ENG-SF18021-R4-CD-redlines.pdf Markup Summary

**REDTAIL RANCH FILING NO. 1
CONSTRUCTION DRAWINGS**
STREET SECTIONS / EROSION CONTROL NOTES

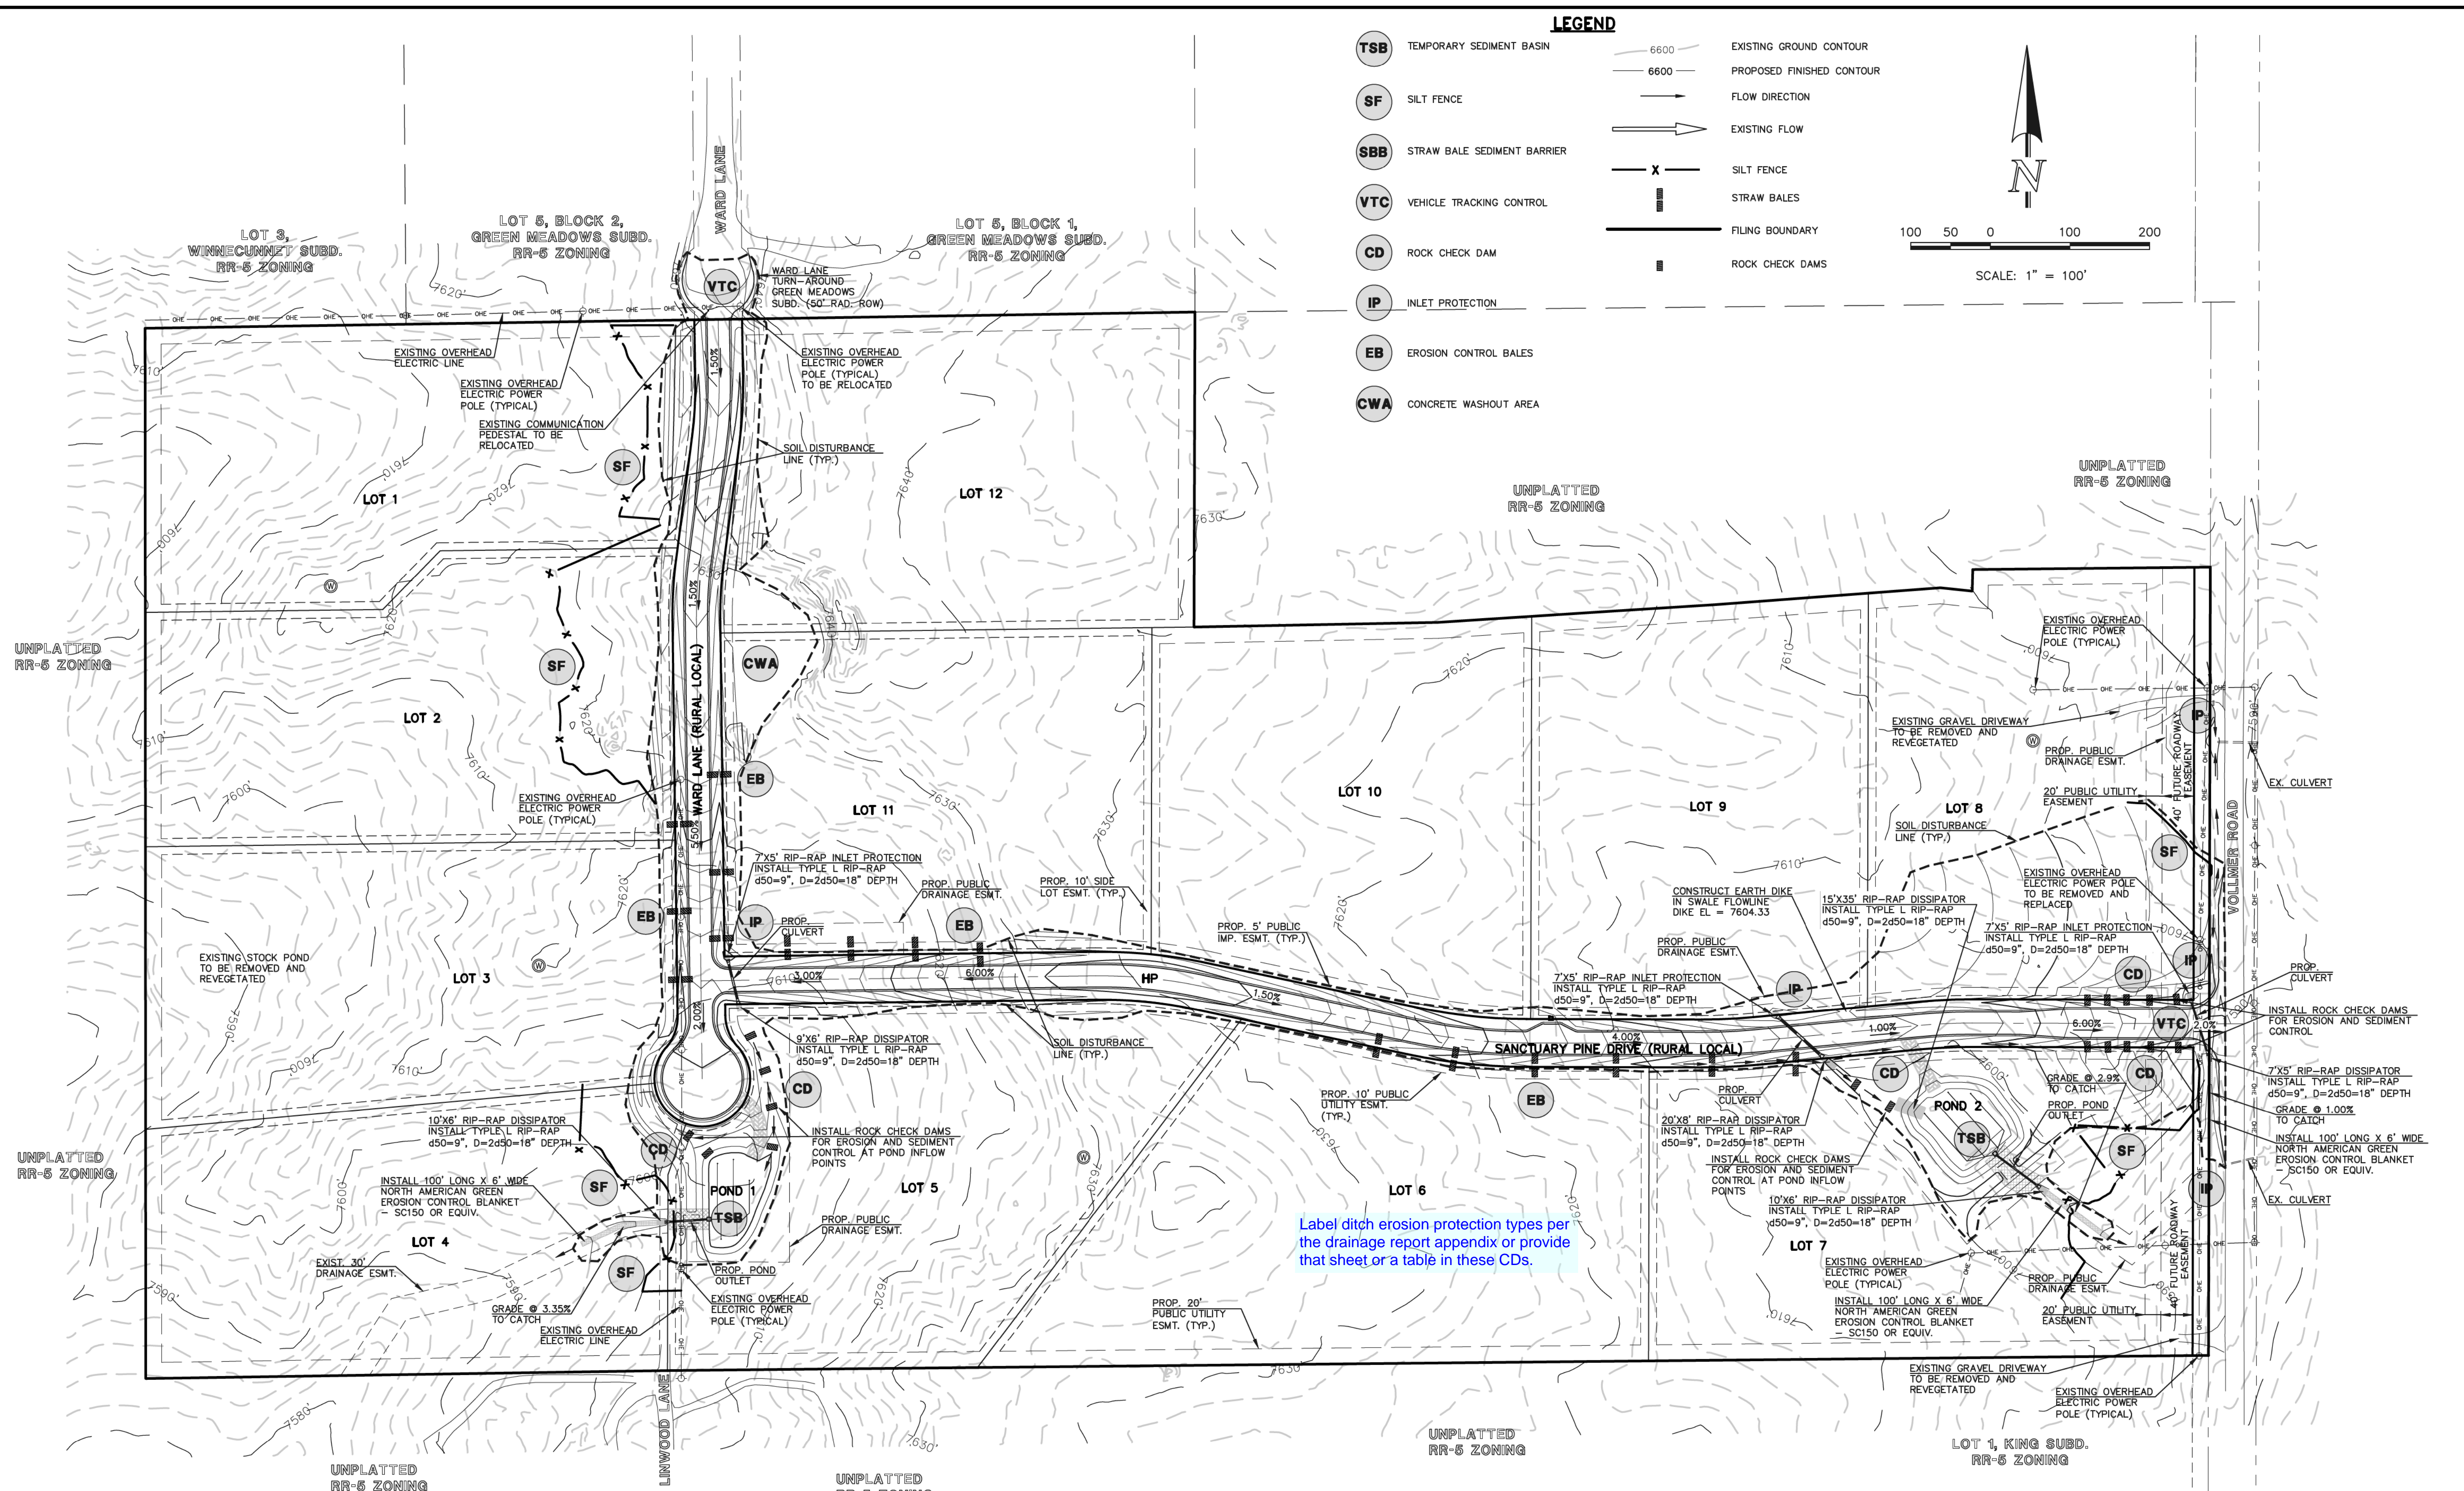
Label ditch erosion protection types per the drainage report appendix or provide that sheet or a table in these CDs.

DESIGNED BY	PRA	SCALE	DATE	06-29-18
DRAWN BY	PRA	(H) 1" = 50'	SHEET	5 OF 10
CHECKED BY	(V) 1" = 5'	JOB NO.	2525.00

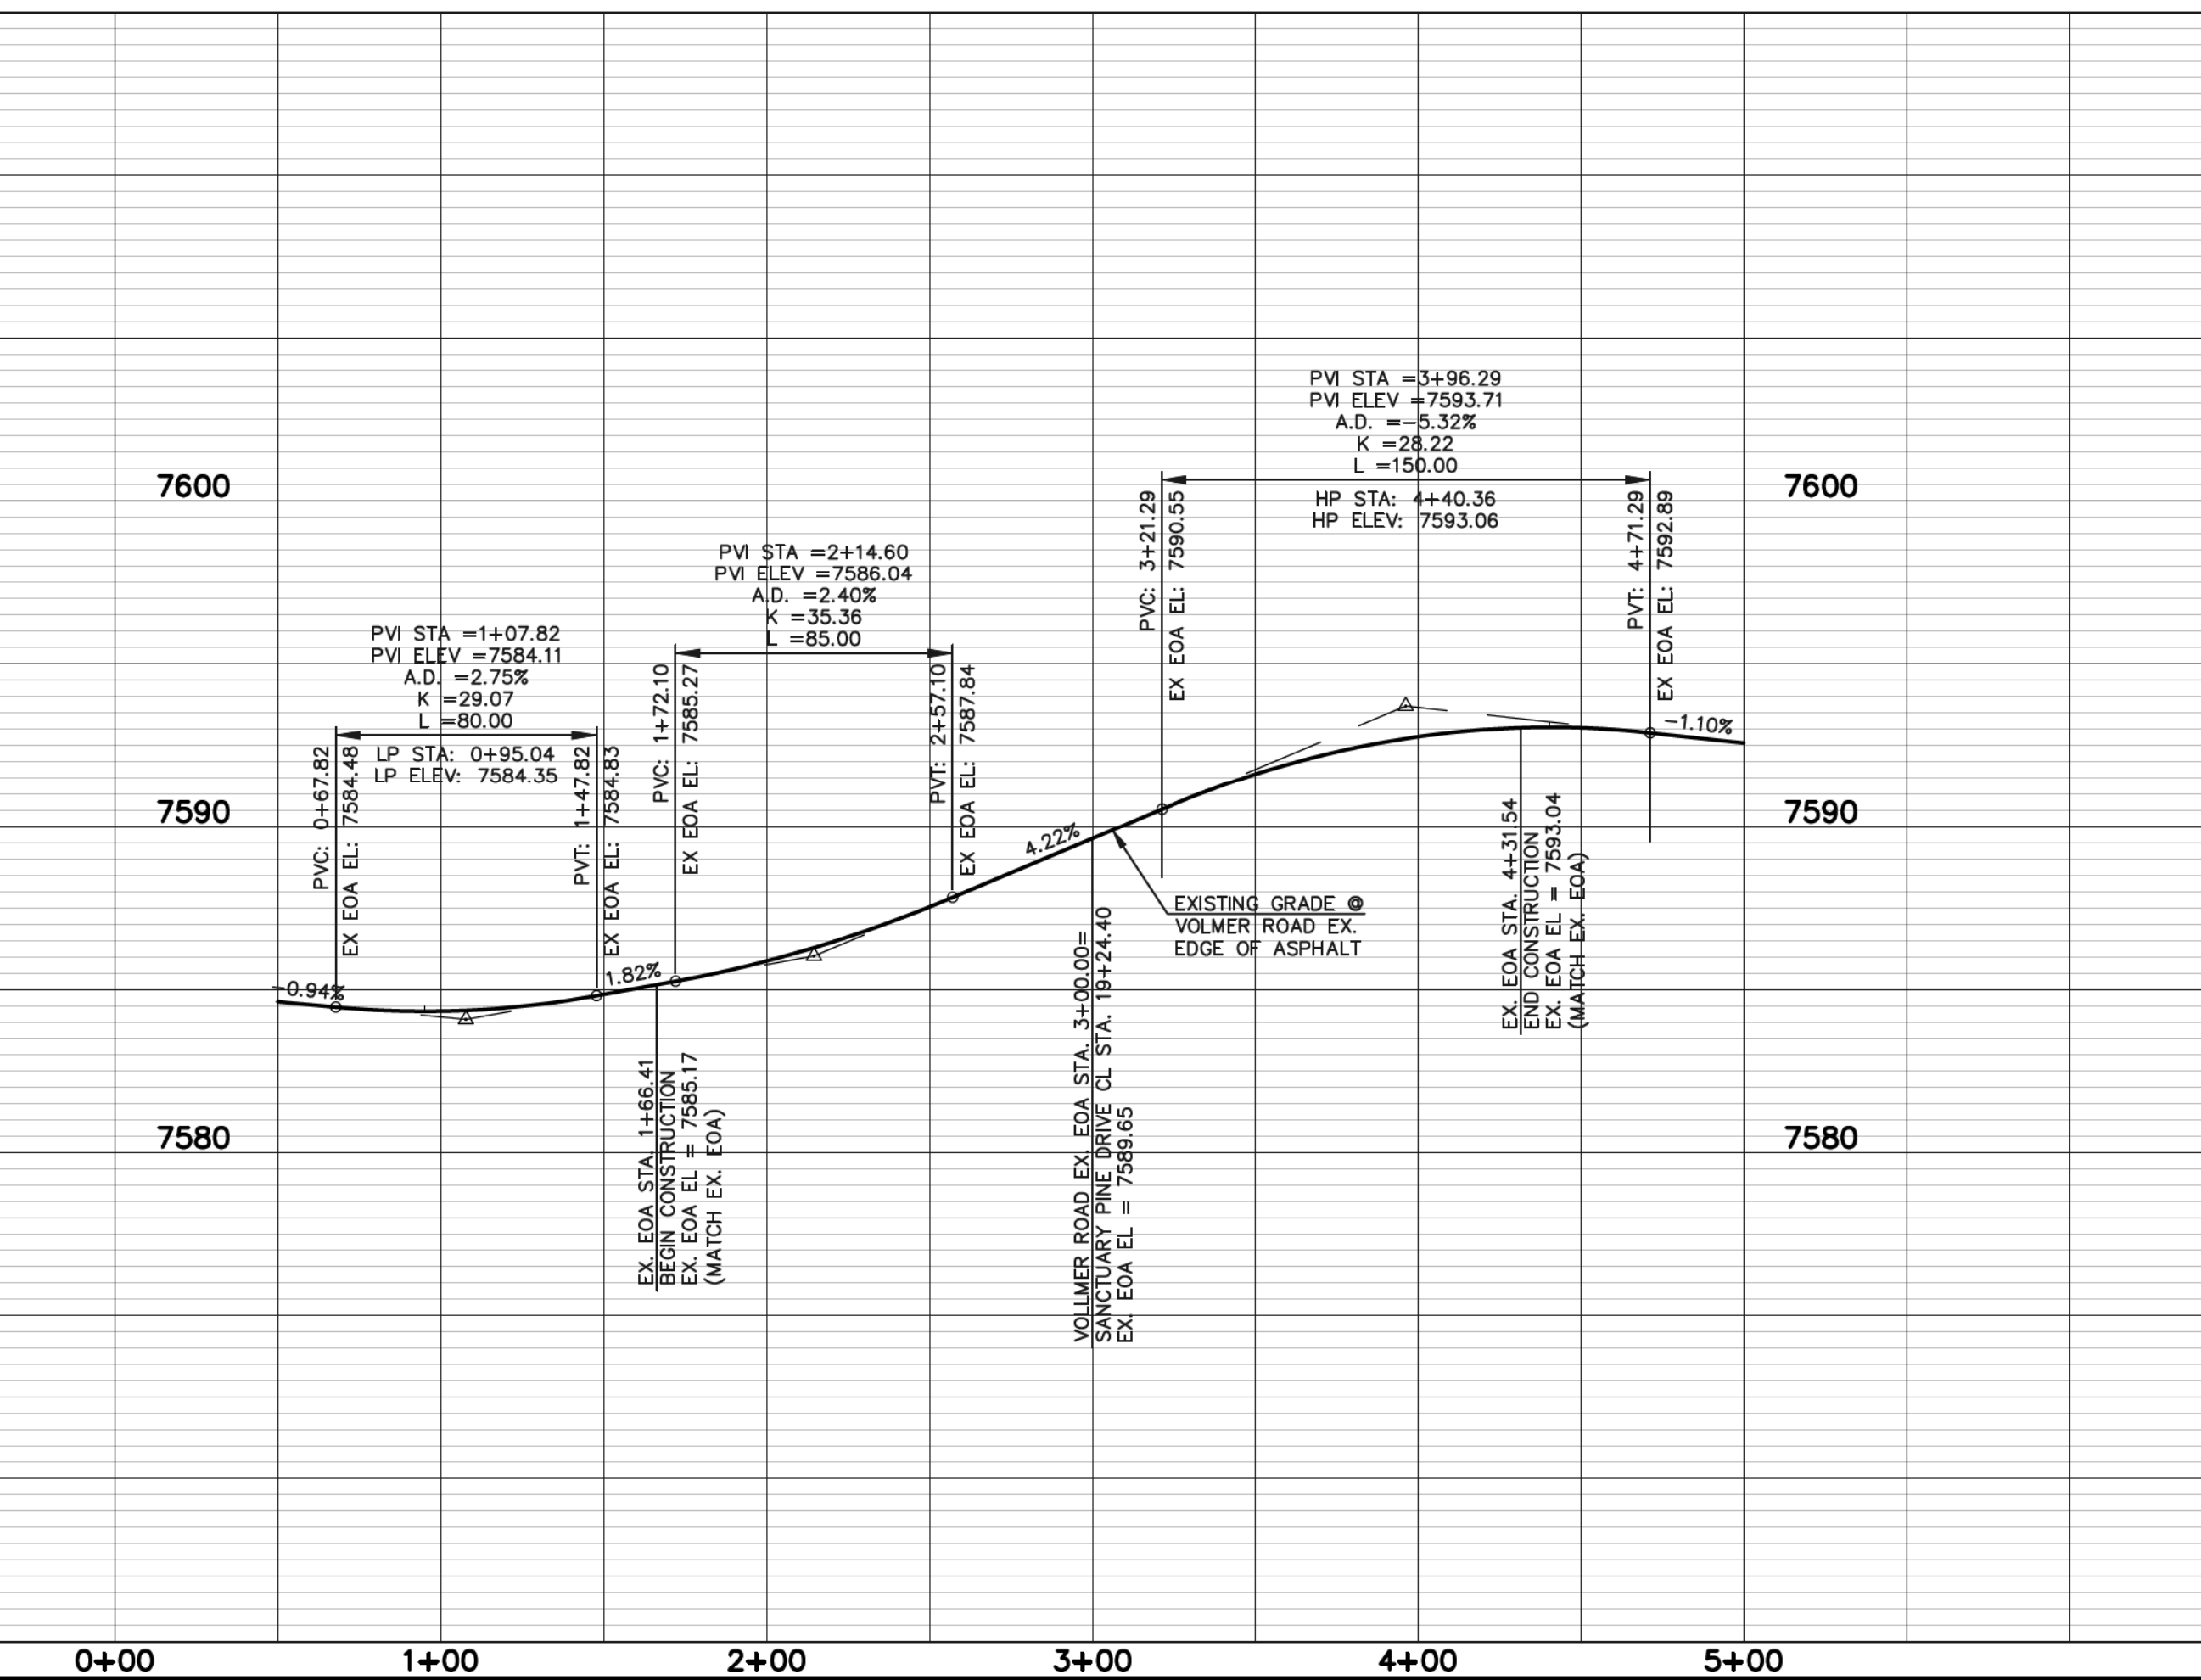
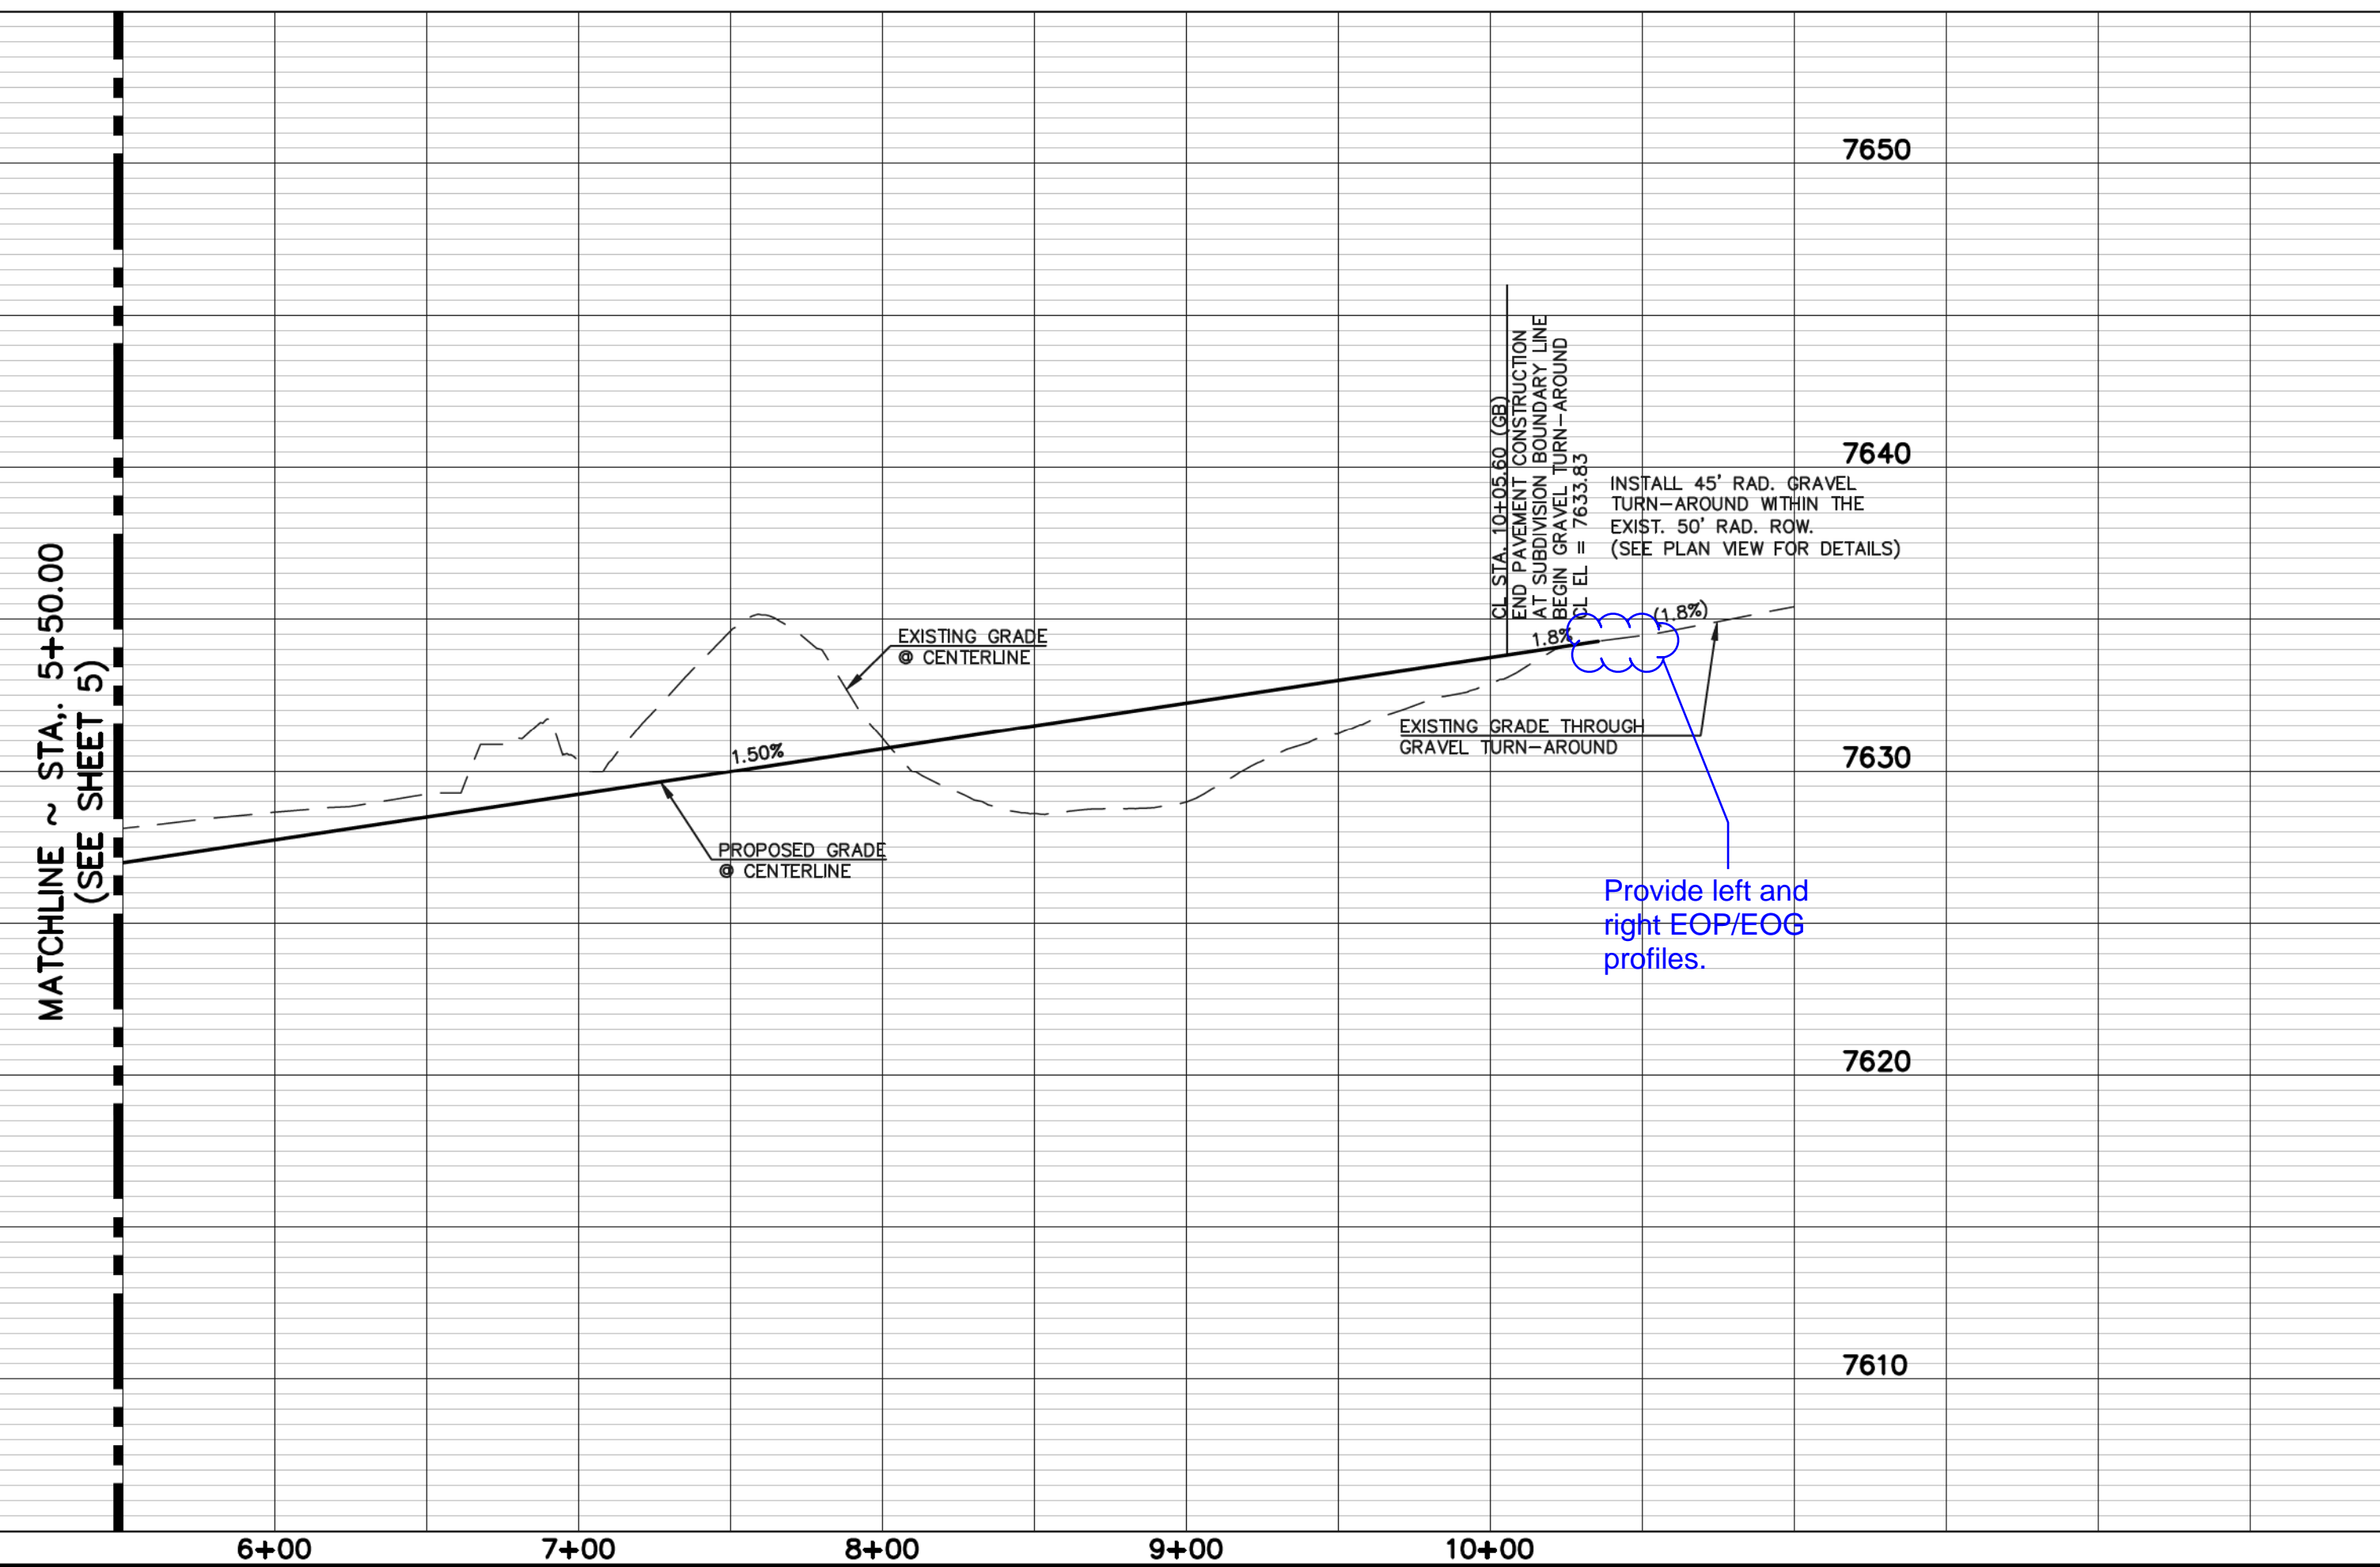
Cross slopes are too high.

Provide left and right EOP/EOG profiles.
